Recommendation Report for Planning Permission for Works or Extension to a Dwelling

REF NO: LU/384/21/HH

LOCATION: 18 Middle Mead
Littlehampton
BN17 6QH

PROPOSAL: Single storey rear extension following demolition of existing rear extension.

DRAWING TITLE
EXISTING FLOOR PLAN AND
ELEVATIONS

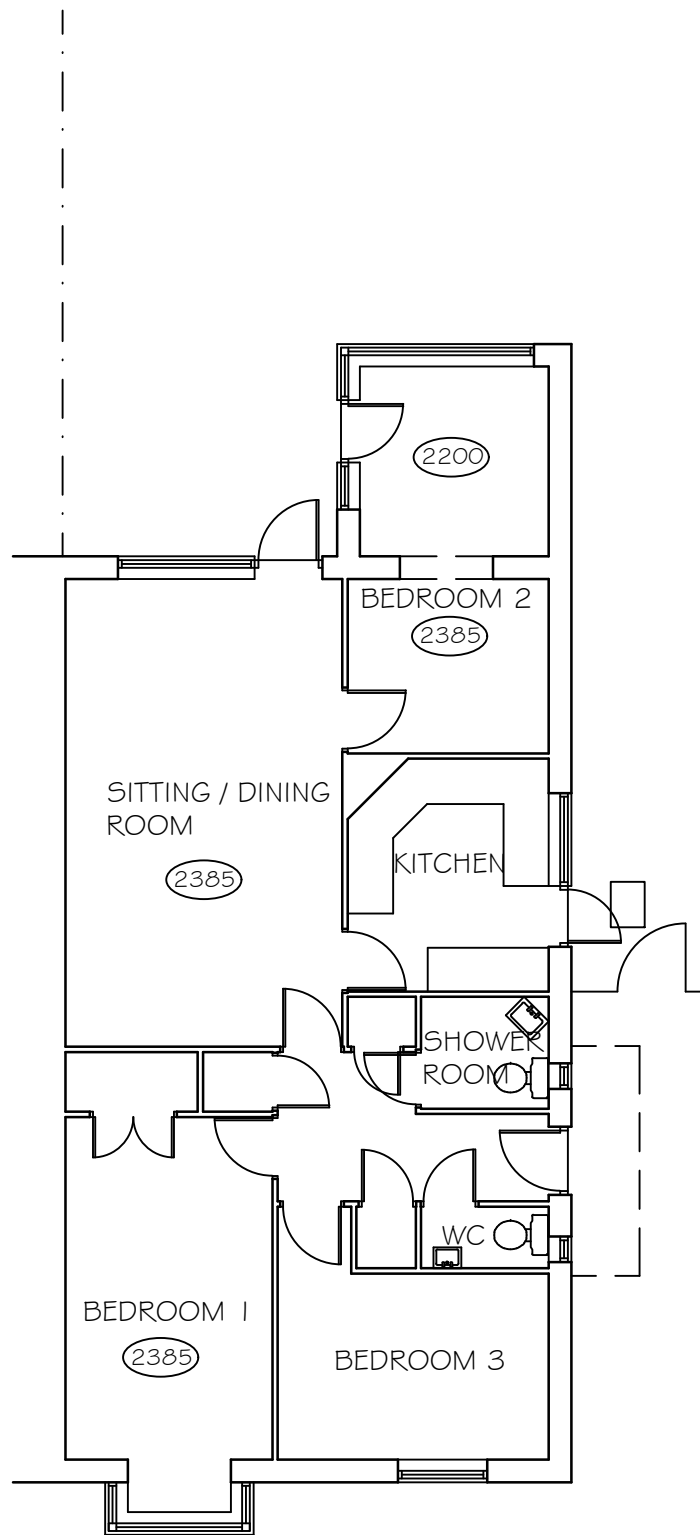
The host dwelling is a semi-detached bungalow with an existing rear extension. The existing rear extension projects approx. 2.8m to the rear, is approx. 3.1m in width and approx. 2.7m in height. The proposal is significantly larger than the existing rear extension but maintains the same approx. height. The proposal is of moderate scale relative to the host dwelling. It projects approx. 3.3m to the rear of the property and extends approx. 7.43m across the full width of the property with a further approx. 0.9m projection to the northern (side) boundary. Section M of the Arun Design guide, states that single storey rear extensions should as a principle, be limited to an approx. depth of 3.3m which is met by this proposal.

DRAWING TITLE
 PROPOSED FLOOR PLAN AND
 ELEVATIONS

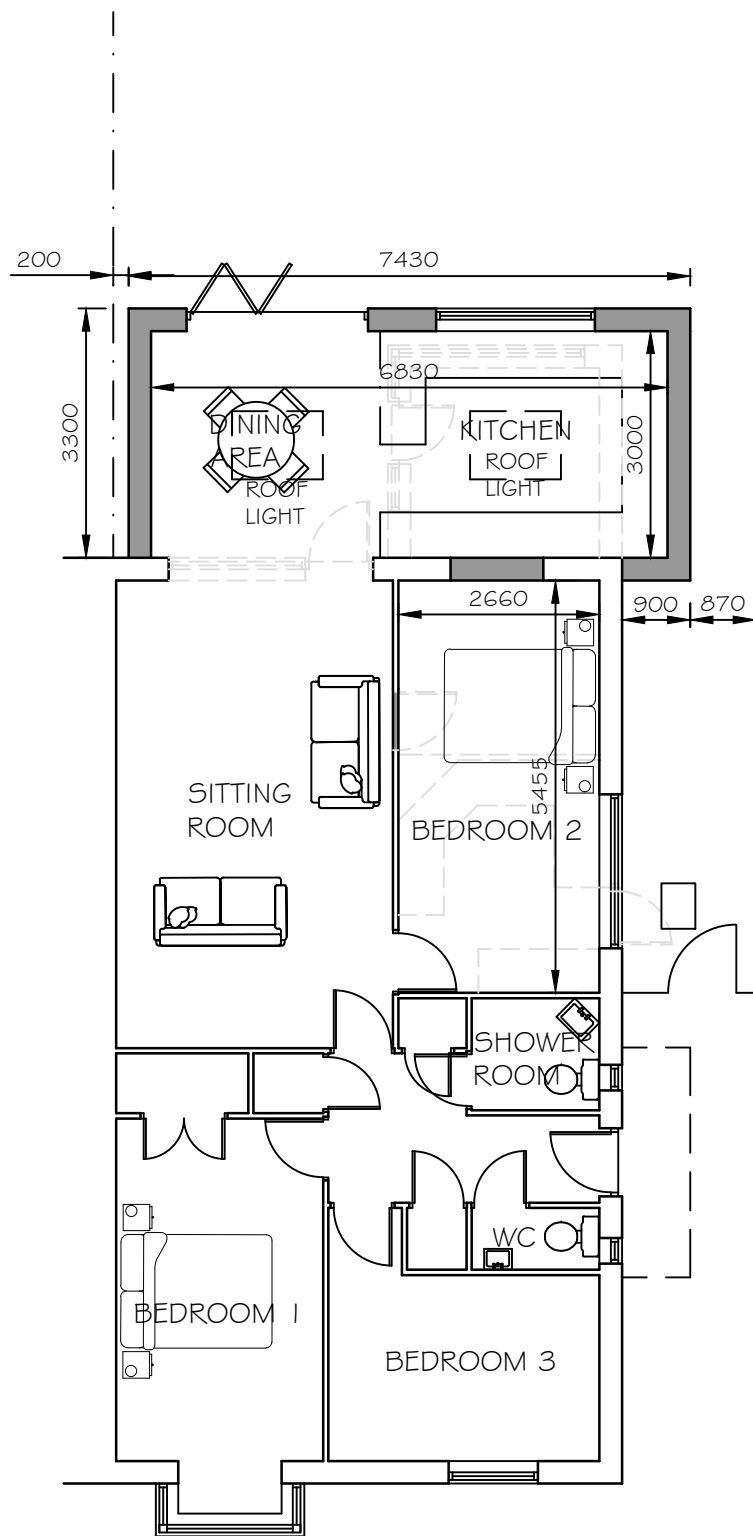
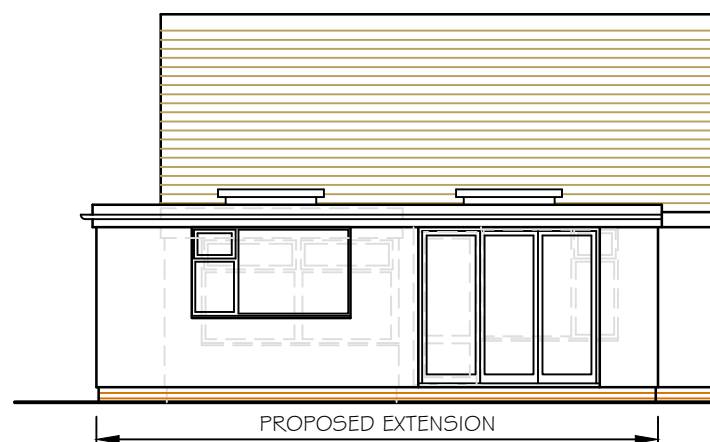
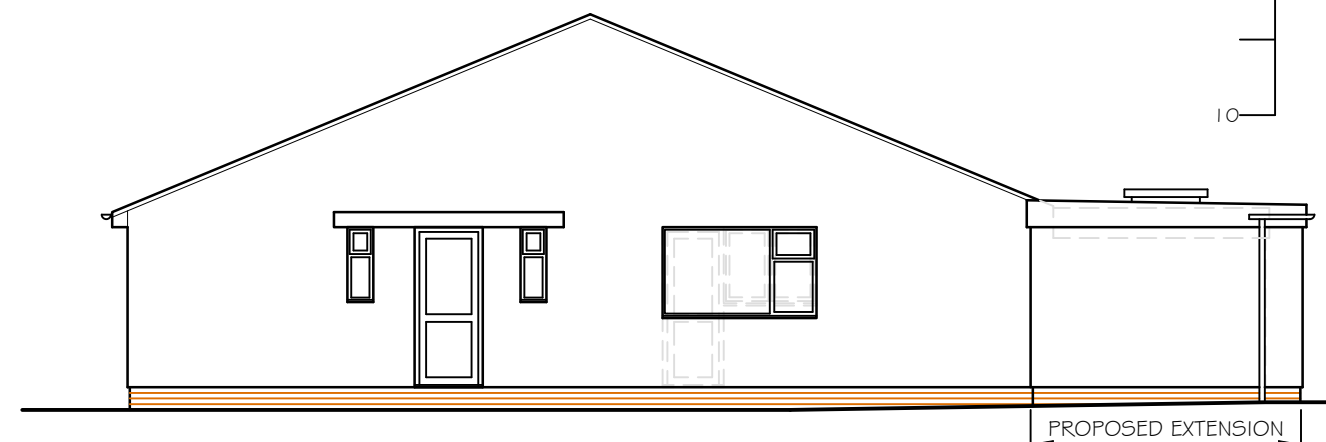
The application seeks to erect a single storey rear extension that projects approx. 3.3m to the rear of the property and extends approx. 7.43m across the full width of the property with a further approx. 0.9m projection to the northern (side) boundary. The proposal incorporates a flat roof design and is approx. 2.7m in height with 2 No. new skylights.

The proposed rear extension also incorporates matching materials to those found on the host dwelling making it visually integrated by design. The proposal, is of moderate scale and despite its projection on the north elevation (approx. 0.9m) remains sympathetic to the host dwelling.

The proposed extension projects approx. 3.3m to the rear of the property which is an appropriate depth following Section M of the Arun Design Guide. Section M also sets in principle, to 60 degree rule. The attached neighbour to the south (17 Middle Mead, Littlehampton) has a rear facing window located close to the southern (connecting) boundary. The 60 degree sightlines from the centre of this rear window are not intersected by the proposal. Furthermore, the 45 degree lines from this neighbouring window are not intersected by the height of the proposal and as such, the proposal does not significantly prevent access to sunlight. Therefore, the amenity of the attached neighbour 17 Middle Mead is not significantly adversely impacted by way of overbearing or overshadowing.

The proposed extension includes a set of rear facing glass doors and a rear facing glass window. These both lookout to the rear garden which retains approx. 11.25m to the rear boundary. These windows are single storey and retain substantial rear depth. They do not provide any viewpoints onto neighbouring properties and as such, do not give rise to any adverse impacts by way of overlooking.

Any viewpoint of the side projection from the front is minimal and obscured by fencing that connects the side of the property to the northern site boundary. Furthermore the visible profile is likely to be minimal and consist of appropriate visual design and integration. As such, this proposal does not negatively impact the street scene.
